Appendix F. Road safety audit response report template for stages 1, 2 and 3 only

Report title:	PROPOSED COMMERCIAL DEVELOPMENT, HOUGHTON MAIN, BARNLEY – PROPOSED GHOST ISLAND PRIORITY JUNCTION Combined Stage 1 and 2 Road Safety Audit
Date:	21st March 2022
Document reference and revision:	RSI-MH-0322-004 Issue 1.1
Prepared by:	Road Safety Initiatives
On behalf of:	Barnley Metropolitan Borough Council

Project:	Houghton Main, Barnley
Report title:	Stage ½ RSA Designers response
Prepared by:	
Name:	Rik Binnersley
Position:	Principal Engineer
Signed:	
Organisation:	RWO Group Leeds
Date:	30.03.2022
Approved by:	
Name:	Andrew Fairburn
Position:	Director
Signed:	
Organisation:	RWO Group Leeds
Date:	30.03.2022

Title SECTION 278 HIGHWAY
DRAINAGE LAYOUT

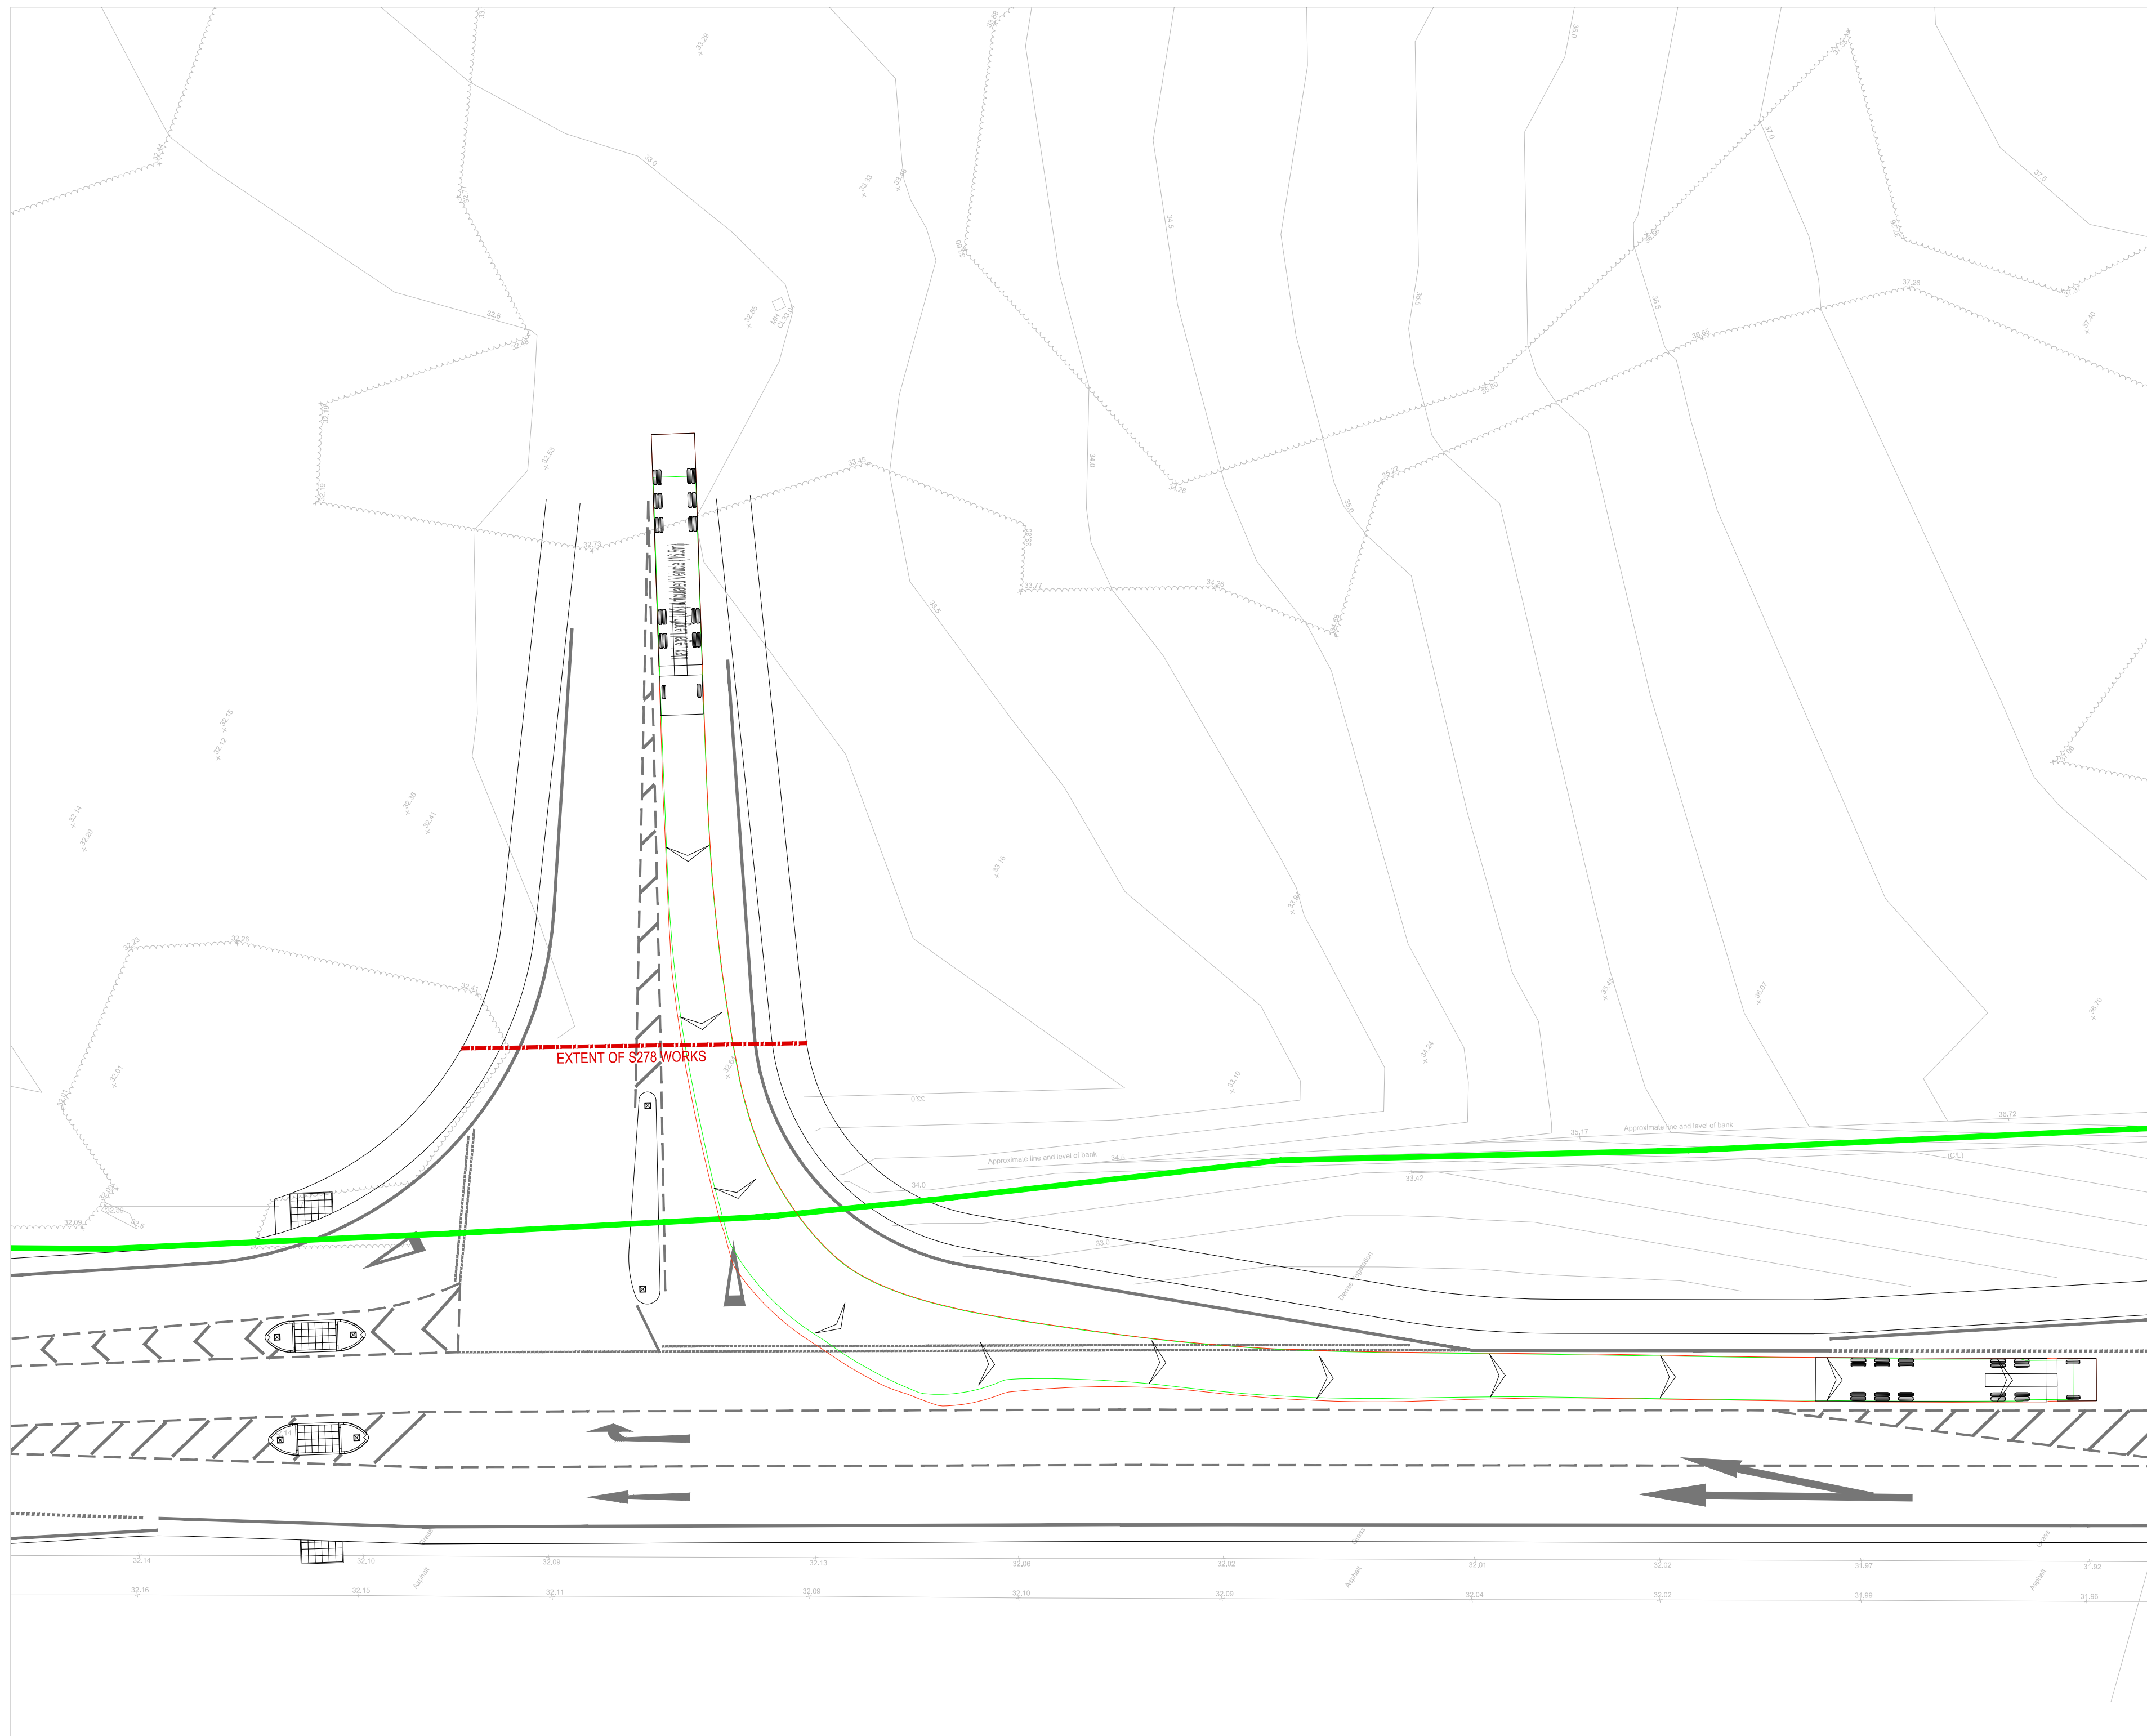
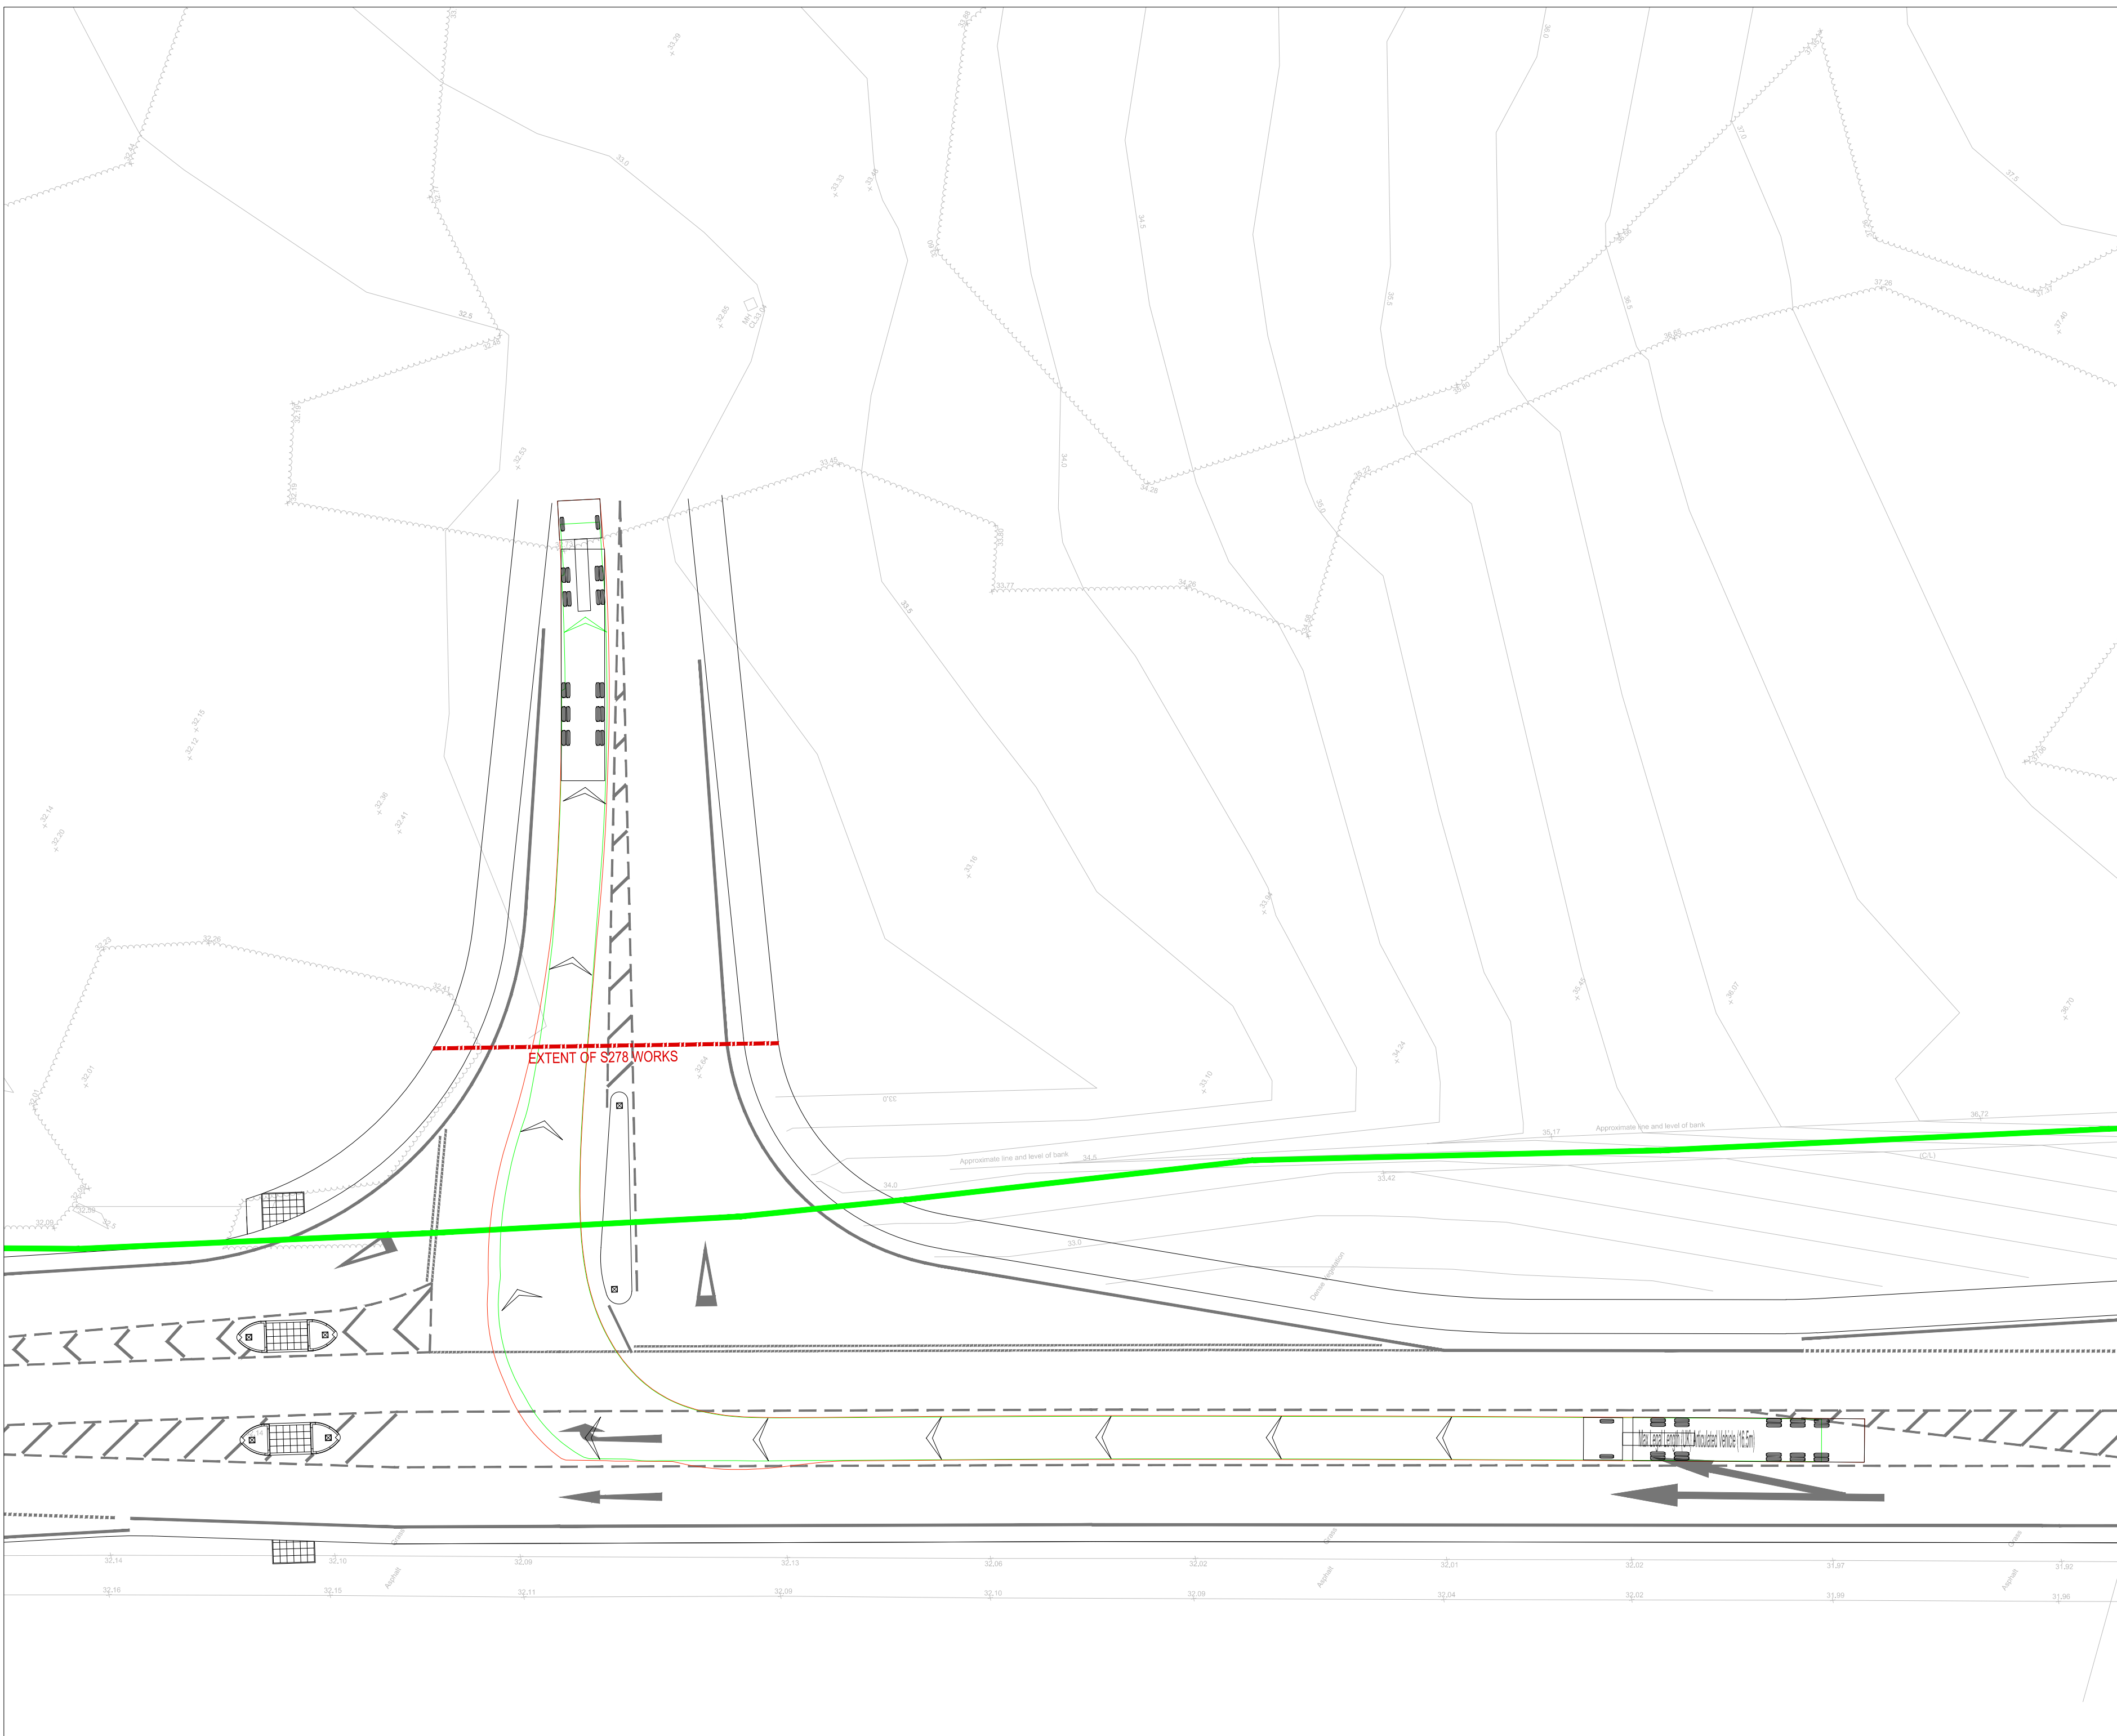
RSA problem	RSA recommendation	Design organisation response	Overseeing Organisation response	Agreed RSA action
3.1.1 - Inadequate drainage may lead to loss of control collisions. It would appear that no drainage is to be provided adjacent to the new kerblane (currently consists of informal 'over the edge' type drainage). The current system results in standing water, which was evident during the site visit. The carriageway is proposed to be widened, which will increase the amount of surface water to be removed and there will be nowhere for it to disperse, which could exacerbate the situation.	It is recommended that adequate drainage is provided.	Agree – At the time of submission of the drawings a drainage scheme for the works was not available. Since this time a preliminary drainage scheme has been produced (Y21011-D1008 – Section 278 Highway Drainage Layout) highlighting how the scheme will be drained.

3.3.4 – Inadequate drainage may lead to pedestrian conflicts. It would appear that no drainage is to be provided adjacent to the new kerbline (currently consists of informal 'over the edge' type drainage). The current system results in	It is recommended that adequate drainage is provided.	Agree – At the time of submission of the drawings a drainage scheme for the works was not available. Since this time a preliminary drainage scheme has been produced (Y21011-D1008 – Section 278 Highway Drainage Layout) highlighting how the scheme will be drained. However, it should be noted that the existing ponding issues seem to be caused by vegetation
